Your Ref: Inet 000002821
Our Ref: P/132/07/
Please ask for:
Mr M Porter

21st November 2007

Rear extension and new first floor with dormer extensions:
32 Cardinals Drive Pagham

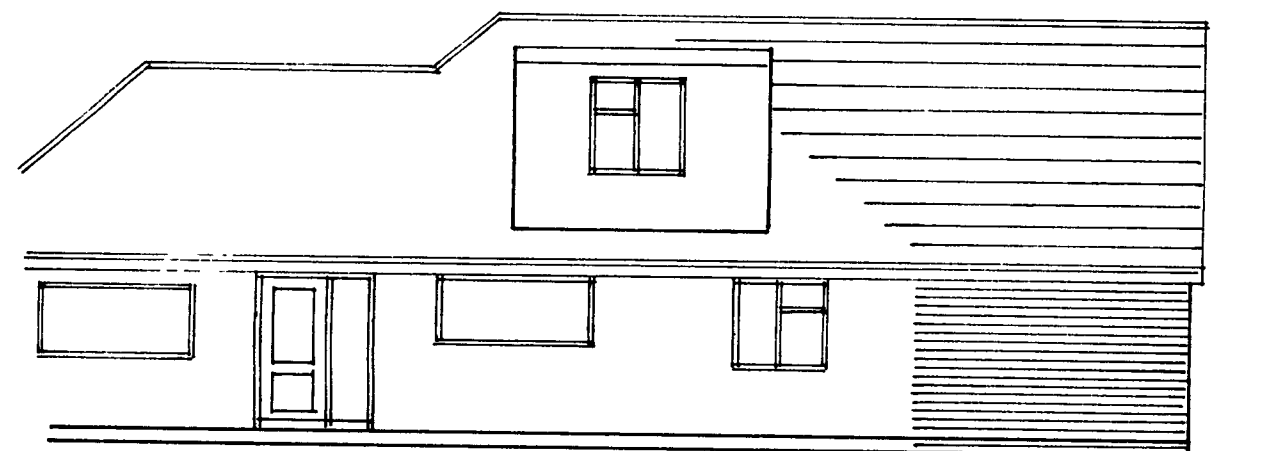
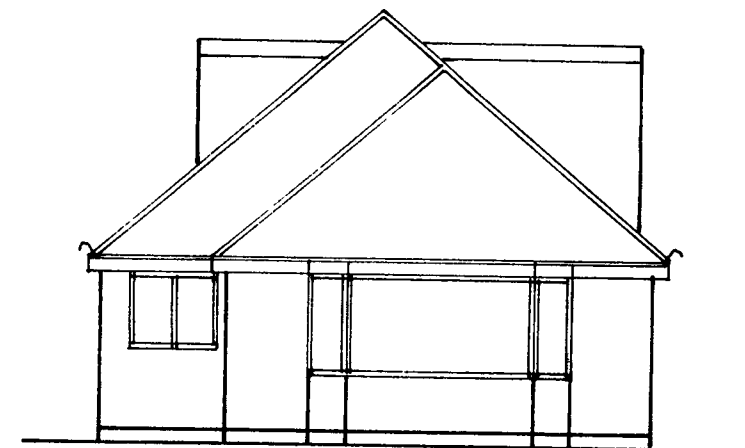
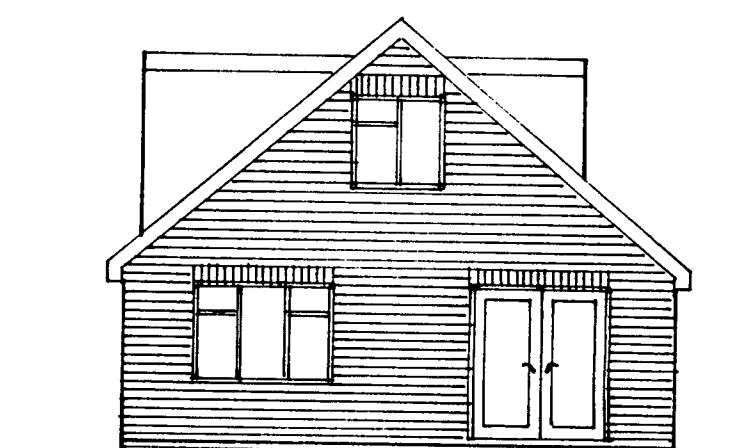
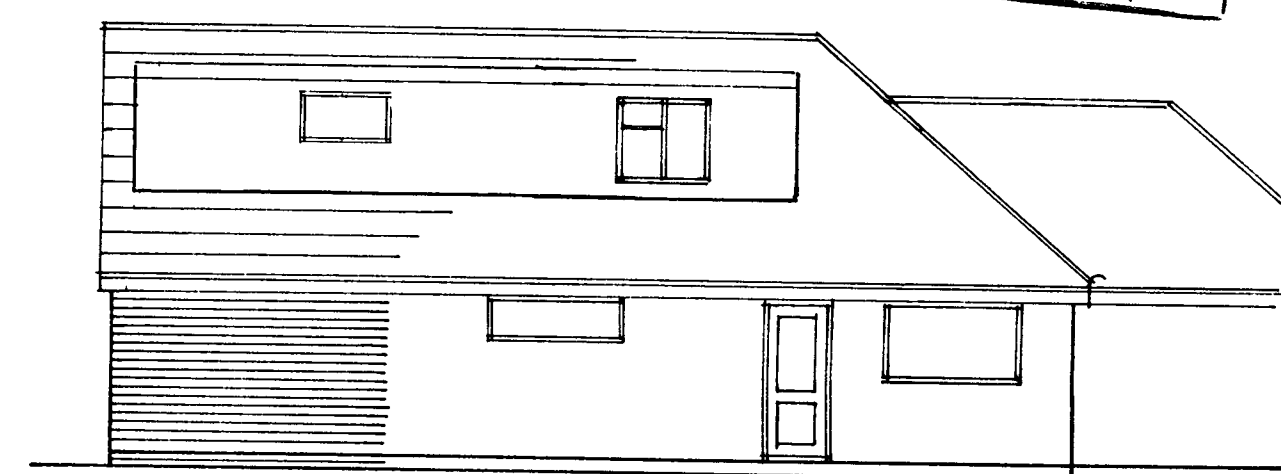
The character and streetscape of Cardinals Drive is of low rise 1960's bungalows without roof conversions. This application, in the opinion of this Council, is therefore contrary to Local Plan Policy DEV 19 (v). In addition the established spatial context is likely to cause any significant roof conversion to have an overlooking and overbearing effect on neighbouring properties contrary to Local Plan Policy DEV 19 (iii) and GEN 7 (iv).
